<b>PROJECT NAME: SEVEN CLOVER DISPENSARY</b>	
<b>ADDRESS:</b> 3641 12TH ST. N.E. ALBUQUERQUE, NM 87108	
Review Date: 5/9/2024	
COA COMMENT	I&A RESPONSE
<b>General (overall) Comments:</b>

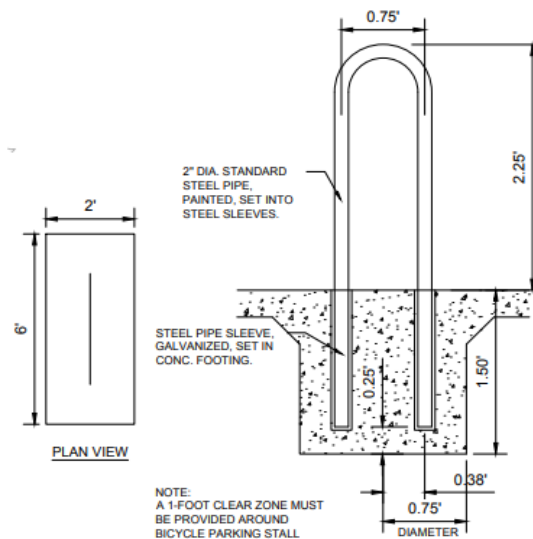
1. SHOW EXITING, ENTRANCES, SIDEWALK, RAMP, AND GUTTER ON THE SITE PLAN.	SHOWN ON THE SITE PLAN.
2. THE BIKE RACK IS TOO SMALL. THE RACK SHALL BE A MINIMUM 30 INCHES TALL AND 18 INCHES WIDE.	THE DETAIL HAS BEEN UPDATED TO REFLECT THIS INFORMATION.

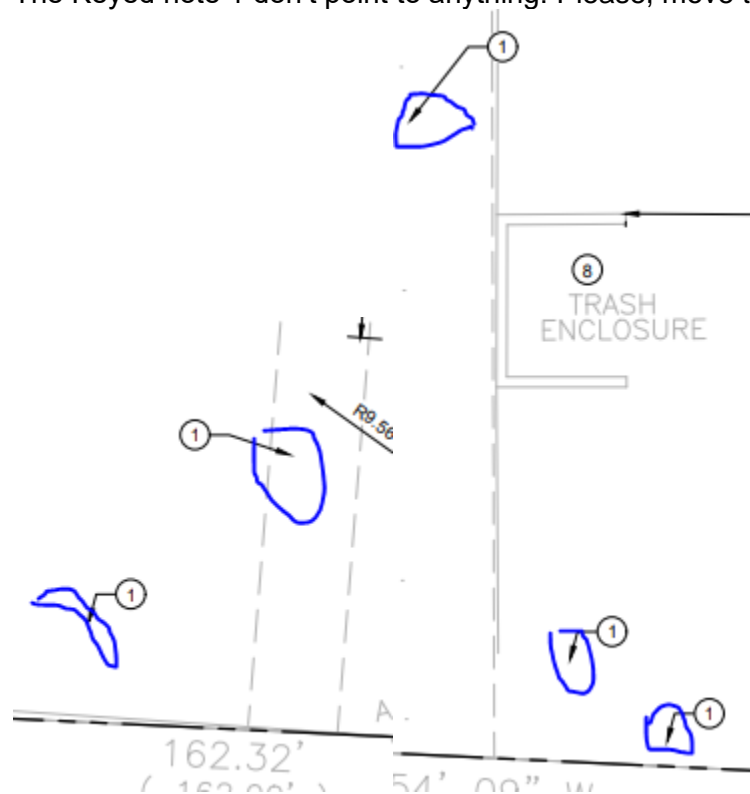
3. BICYCLE PARKING SPACES SHALL BE AT LEAST 6 FEET LONG AND 2 FEET WIDE.	THE BIKE RACKS HAVE BEEN MOVED AND ADJUSTED TO HAVE 6'X2' WITH THE PROPER 1' CLEAR ZONE.

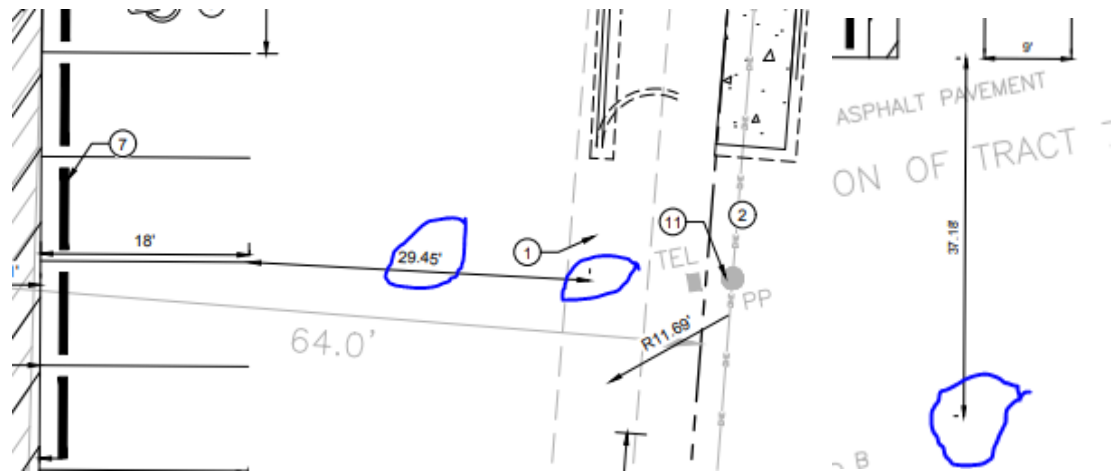
8. THE 29.45' DIMENSION FOR THE EAST DRIVE AISLE AND THE 37.19' DIMENSION ON THE SOUTH SIDE OF THE BUILDING DO NOT POINT TO ANYTHING ON THE EAST SIDE.	EXISTING BACKGROUND WAS MISTAKENLY FROZEN ON PREVIOUS SUBMITTAL PDF. REVISED TO SHOW EXISTING BACKGROOUND, ALL DIMENSIONS SHOULD BE POINTING TO THEIR PROPER BOUNDS.

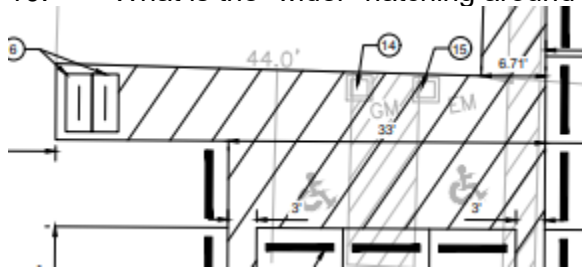
9. THE NEW SIDEWALK IS TO MATCH THE COLOR OF THE EXISTING SIDEWALK. PLEASE REVISE KEYED NOTE 4	REVISED TO COMPLY.
10. WHAT IS THE 'WIDER' HATCHING AROUND THE BUILDING SUPPOSED TO REPRESENT?	HATCH PREVIOUSLY SHOWN TO DENOTE PEDESTRIAN AREA BETWEEN BUILDING AND PARKING. HATCH / STRIPING HAS BEEN REMOVED IN CURRENT REVISION.

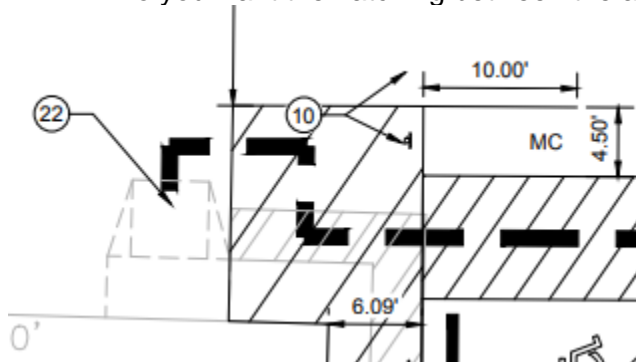
11. DO YOU WANT THE HATCHING BETWEEN THE ACCESIBLE AISLE AND THE DOOR TO BE PAINTED?	HATCH HAS BEEN REMOVED
12. PROVIDE THE WIDTH OF THE SIDEWALK FROM 12TH ST ONTO THE SITE.	SW DIMENSION ADDED TO SHEET.

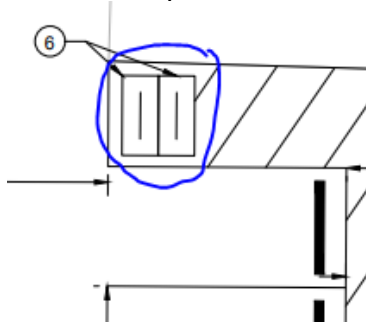
13. WILL THE BICYCLE RACKS INTERFERE WITH SIDEWALK USAGE FOR CUSTOMERS THAT PARK WEST OF THE ACCESIBLE SPACES SOUTH OF THE BUILDING.	BIKE RACKS RELOCATED TO OPPOSITE SIDE OF THE BUILDING, WEST OF THE MAIN ENTRY.
